Online Comment

Application H02-0476-26
Location Land South of Barn Lodge Hereward Way Crowland PE6 0BL
Proposal Details of proposed means of foul and surface water disposal, external materials, Construction Management Plan and Method Statement (Conditions 3, 7 and 10 of H02-0598-25)

Name Diane Gordon
Address SHDC Environmental Health

CONSTRUCTION METHOD STATEMENT - construction of 3 dwellings incl. private driveway.

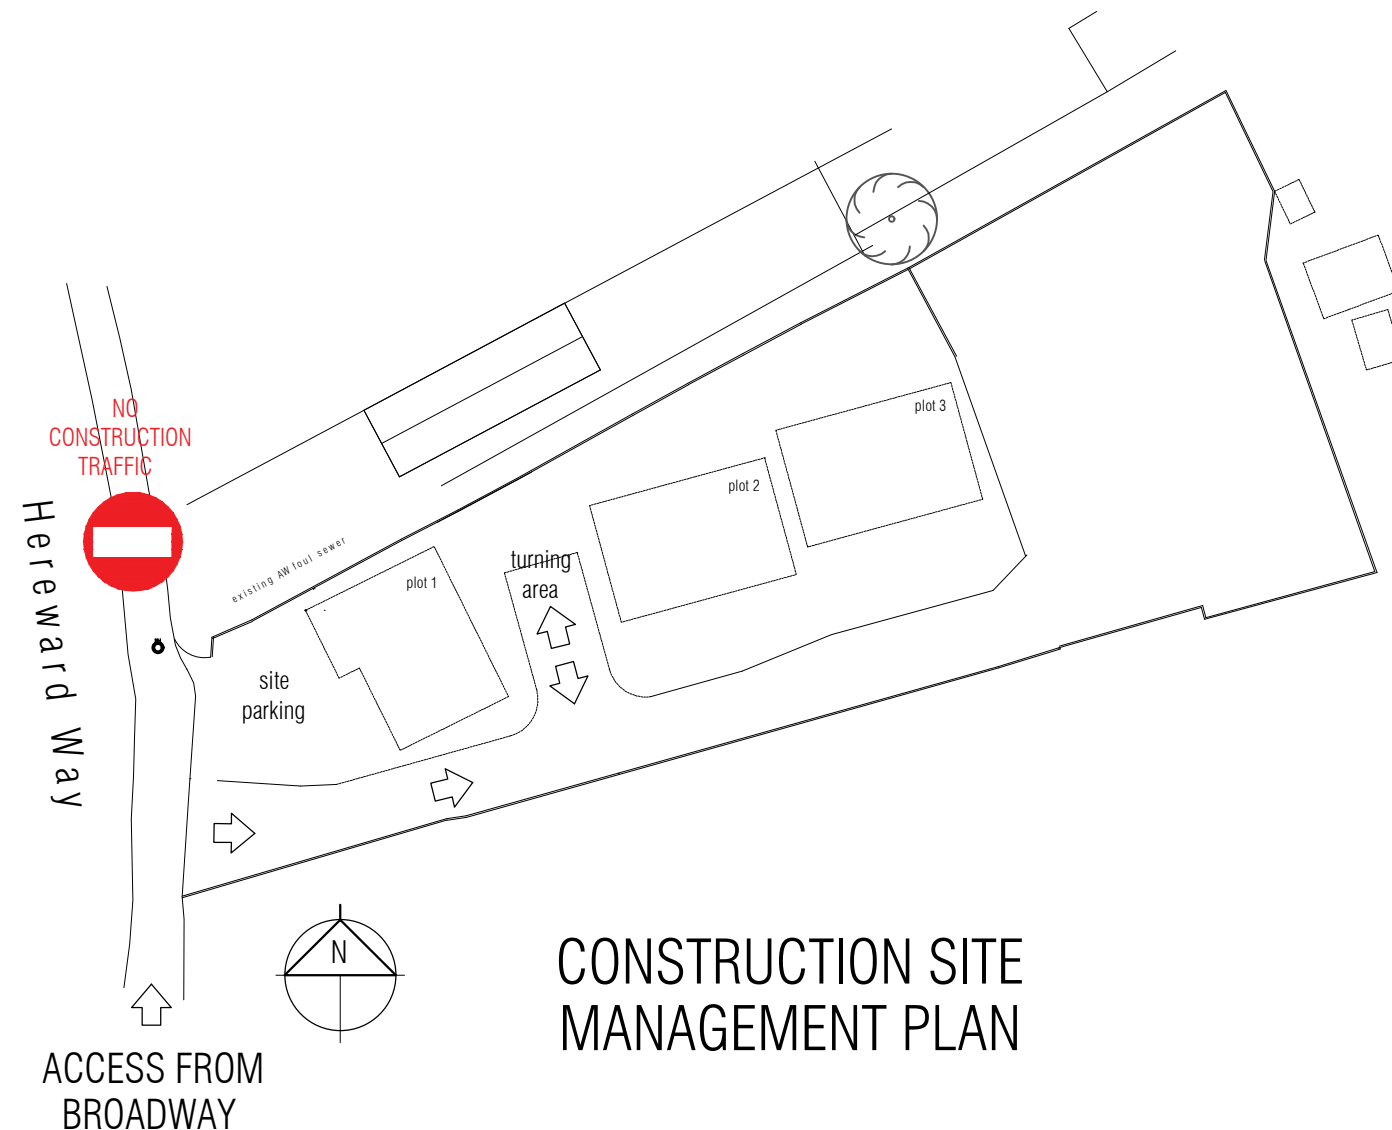
We would not support working hours of 08:00-16:00 on Saturdays due to close proximity to other residential properties, except by prior arrangement for specific purposes.
